Subject: Project EnergyConnect (NSW - Eastern Section) - Biodiversity Offset Package

I refer to the Biodiversity Offset Package (Rev B, prepared by Transgrid and dated 14 September 2022) submitted in accordance with condition C24 of the approval for Project EnergyConnect (NSW - Eastern Section) (SSI-9172452).

Attachment 1: Minor changes required to Biodiversity Offset Package (Rev B, prepared by Transgrid and dated 14 September 2022)

Figure 3: 'Big Bend' BSA 1

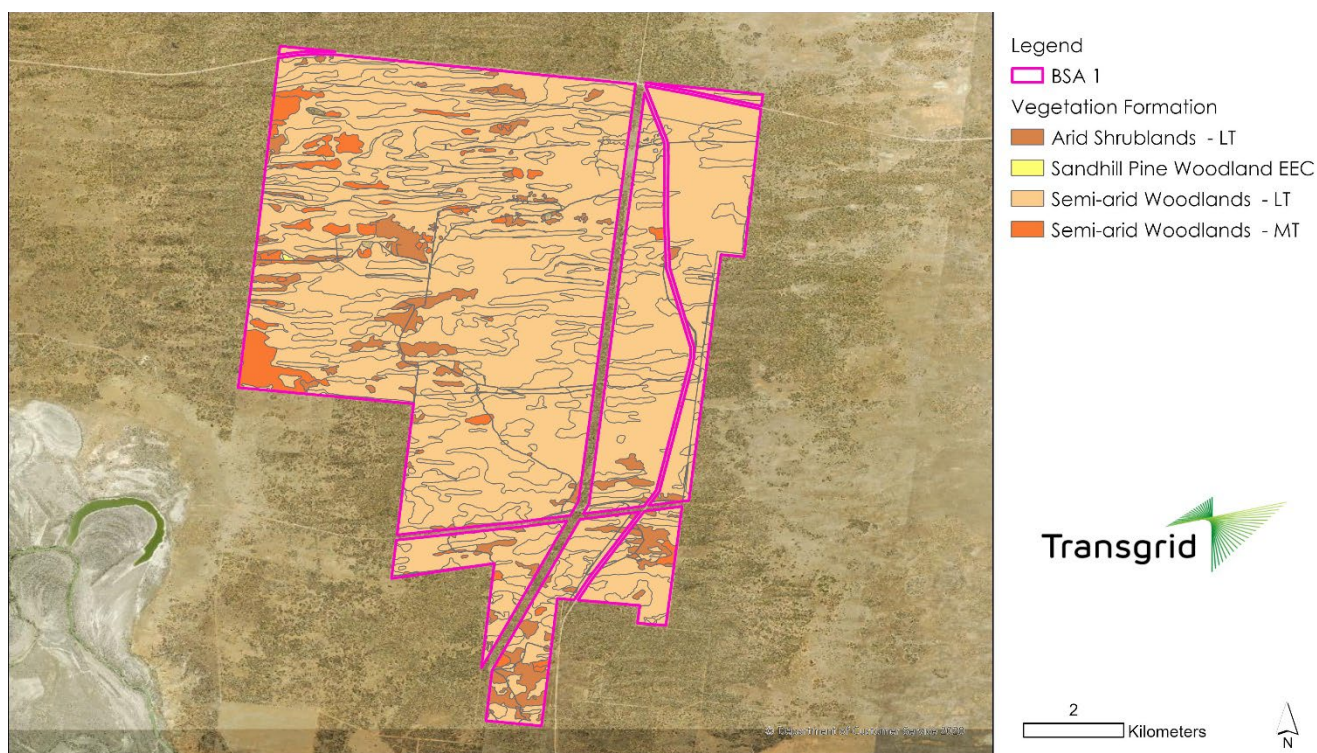
1. Update references in the Biodiversity Offset Package to match Infrastructure Approval SSI-9172452, dated 2 September 2022, and conditions C23, C24, C25 and C26 of the Infrastructure Approval.

Note eg. need to correct references to SSI-10040 (p i) and condition D25 (p 33), where reference is instead meant to the Project EnergyConnect (NSW - Eastern Section) Infrastructure Approval.

2. Update the "Error! Reference source not found" cross reference in Footnote 1 to Table 5 on page 13.
3. In section 1.3.2, delete the second last sentence of the first paragraph on page 4, and insert: "Transgrid will apply for a modification to the Infrastructure Approval, where required, to cover additional clearing", in order to reflect the requirements of the Infrastructure Approval.
